**KIRKLEES METROPOLITAN COUNCIL
INVESTMENT & REGENERATION SERVICE**

Reference No: 2017/62/93660/E

Site Address: 68, Daisy Hill, Dewsbury, WF13 1LS

Description: Change of use from office (A2) to 4 flats, installation of rooflights and new windows and doors (within a Conservation Area)

Planning
DATE
12.10.17
SCALE
1:5@A1
DRAWN BY
M N Ali
REVIEWED BY
DRAWING NUMBER
WF/07/P04

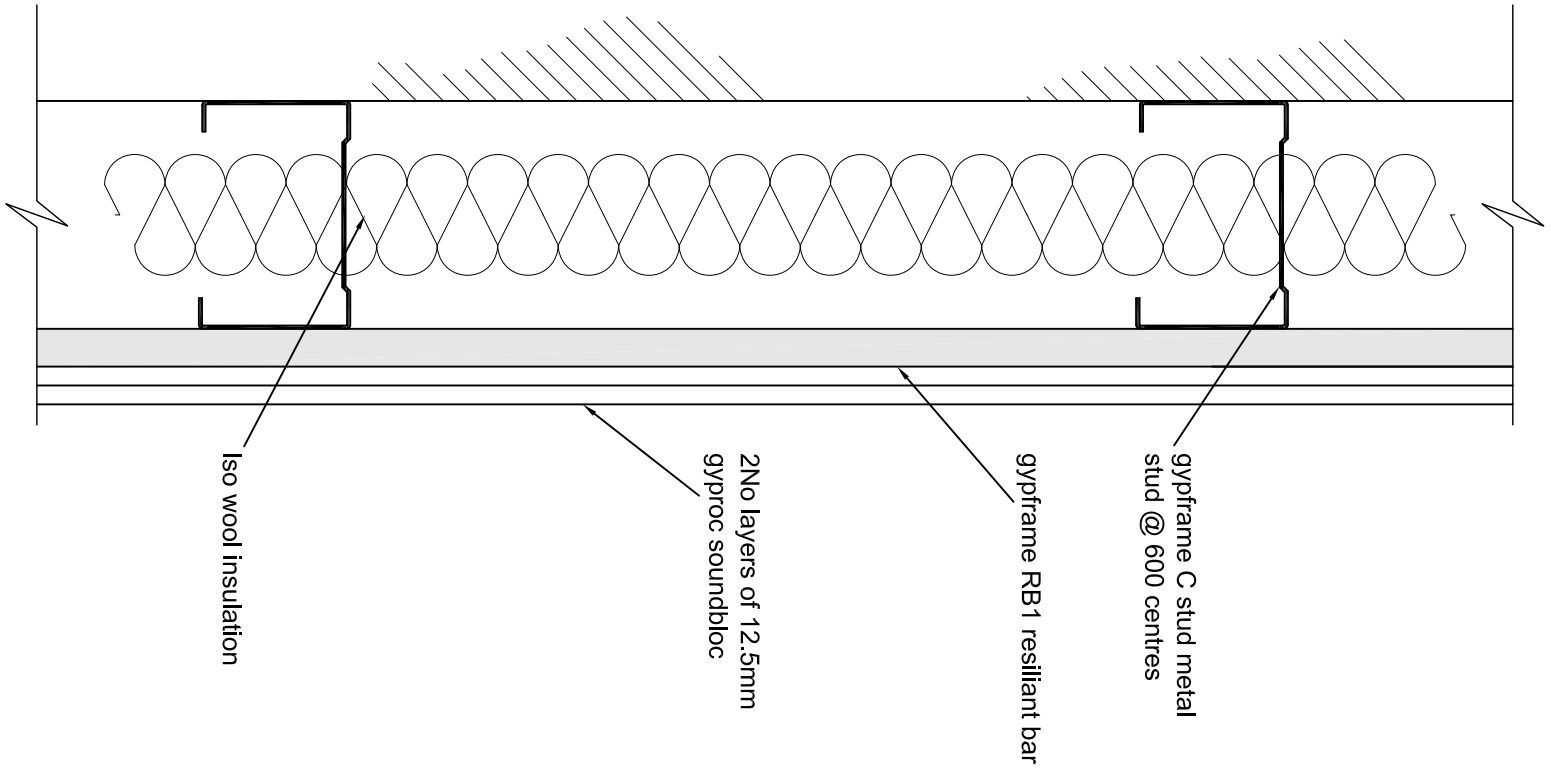
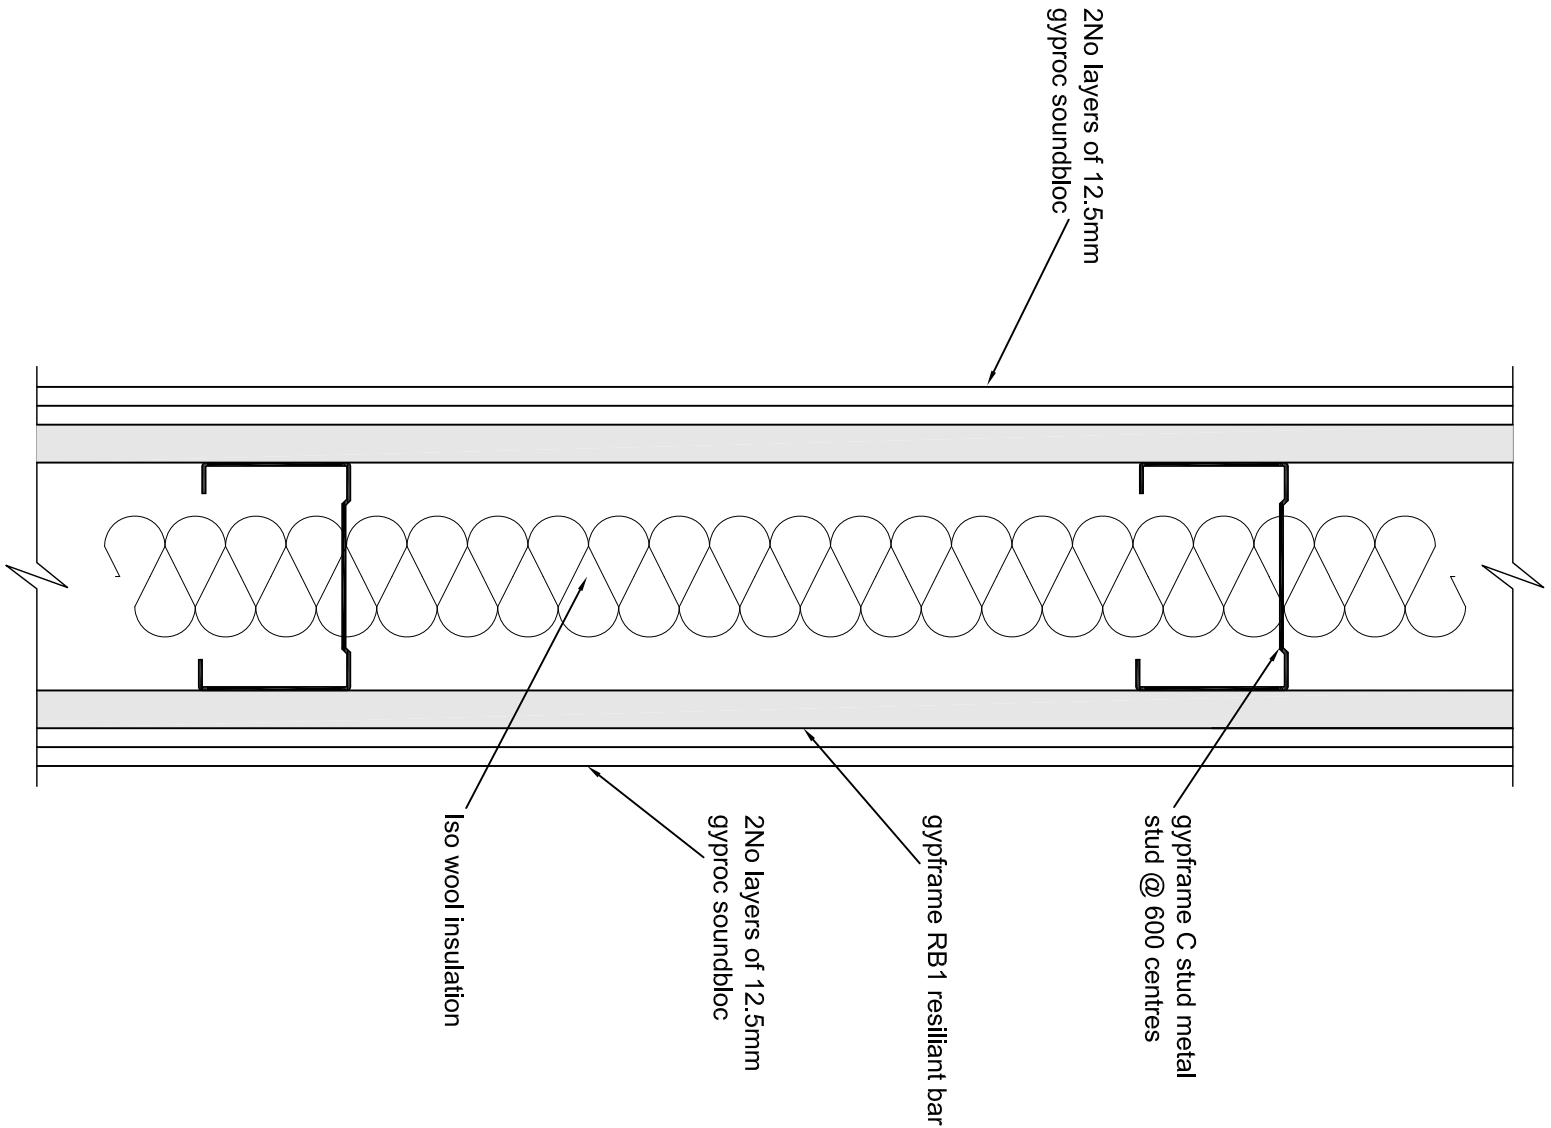
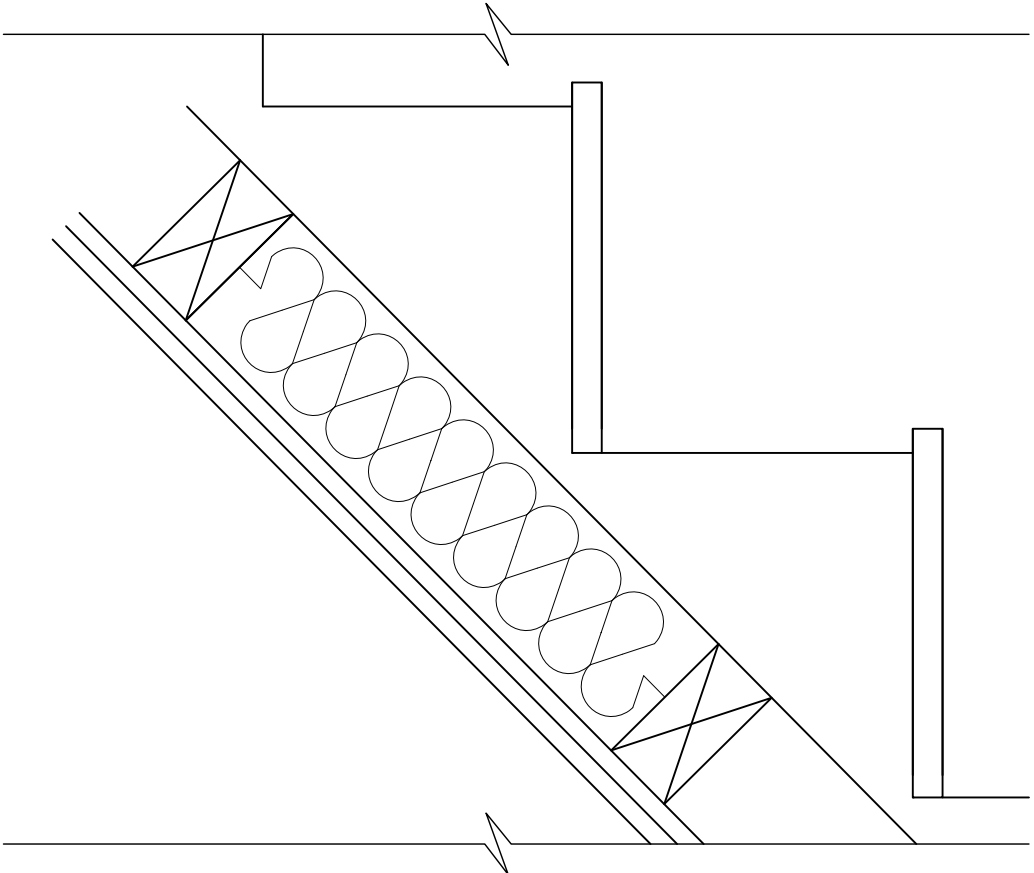
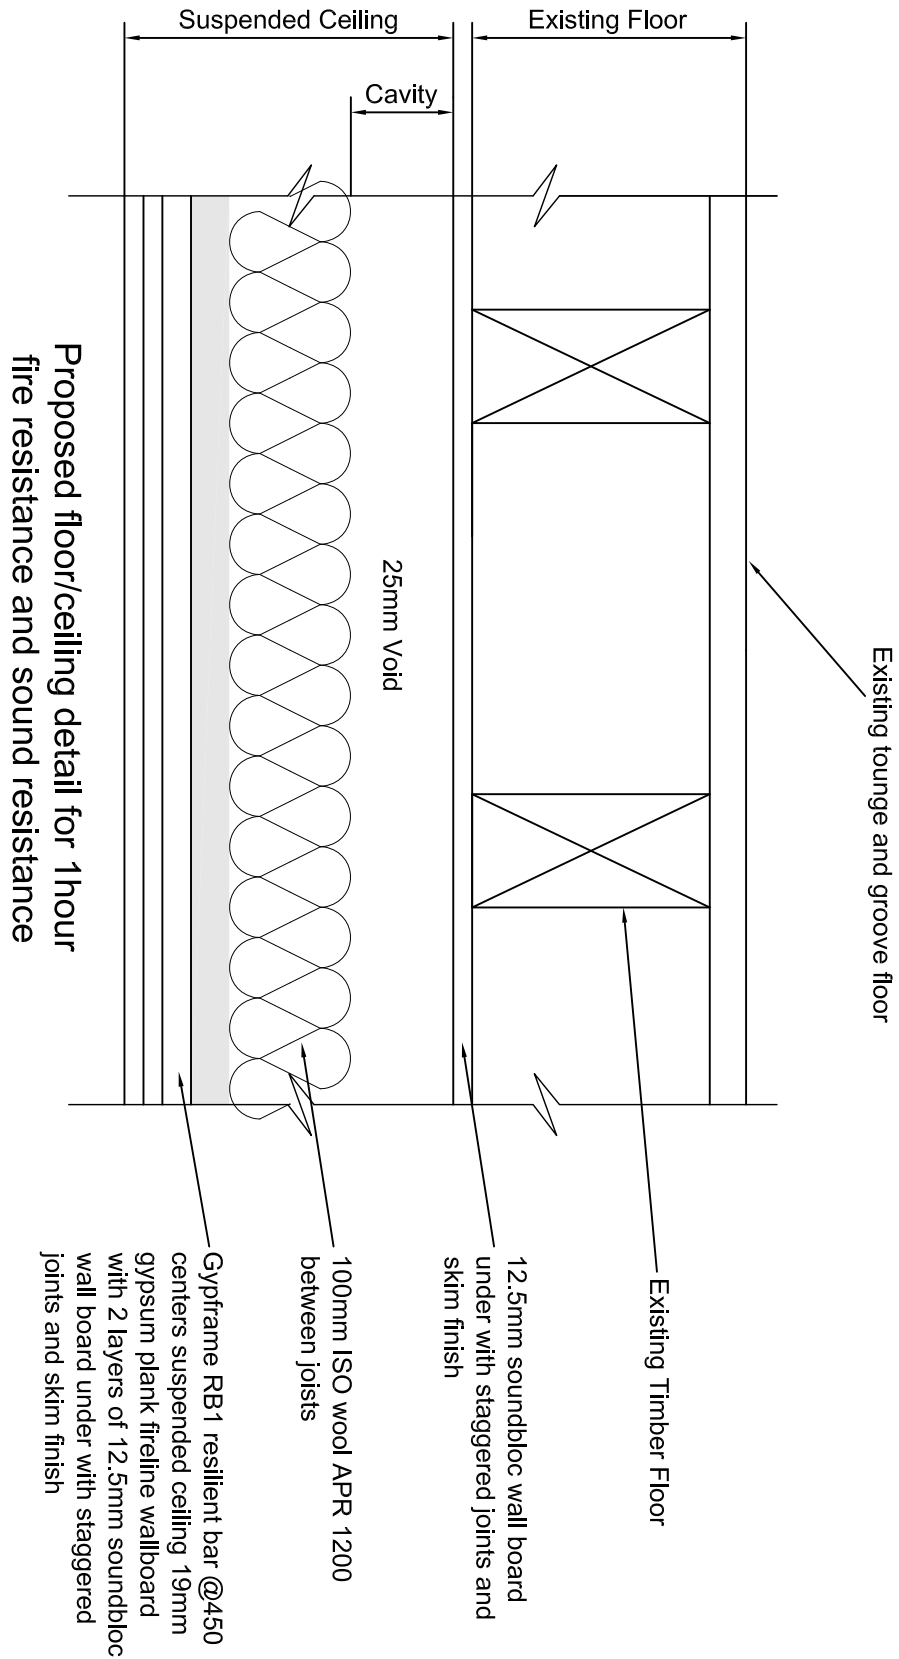
With regard to the impact of noise from traffic and the adjacent uses, Environmental Health has been consulted and has not objected to the proposal. However, following an informal consultation following receipt of this response, a condition has been recommended to require a noise report to be submitted showing how the development can be carried out without adversely impacting the future occupiers of the flats. This would also include any noise

7. Before development commences, a report specifying the measures to be taken to protect the development from noise from local commercial premises and road traffic shall be submitted to and approved in writing by the local planning authority.

The report shall:-

- (i) Determine the existing noise climate
- (ii) Predict the noise climate in bedrooms (night-time) and other habitable rooms of the development.
- (iii) Detail the proposed attenuation/design necessary to protect the amenity of the occupants of the new residences (including ventilation if required).
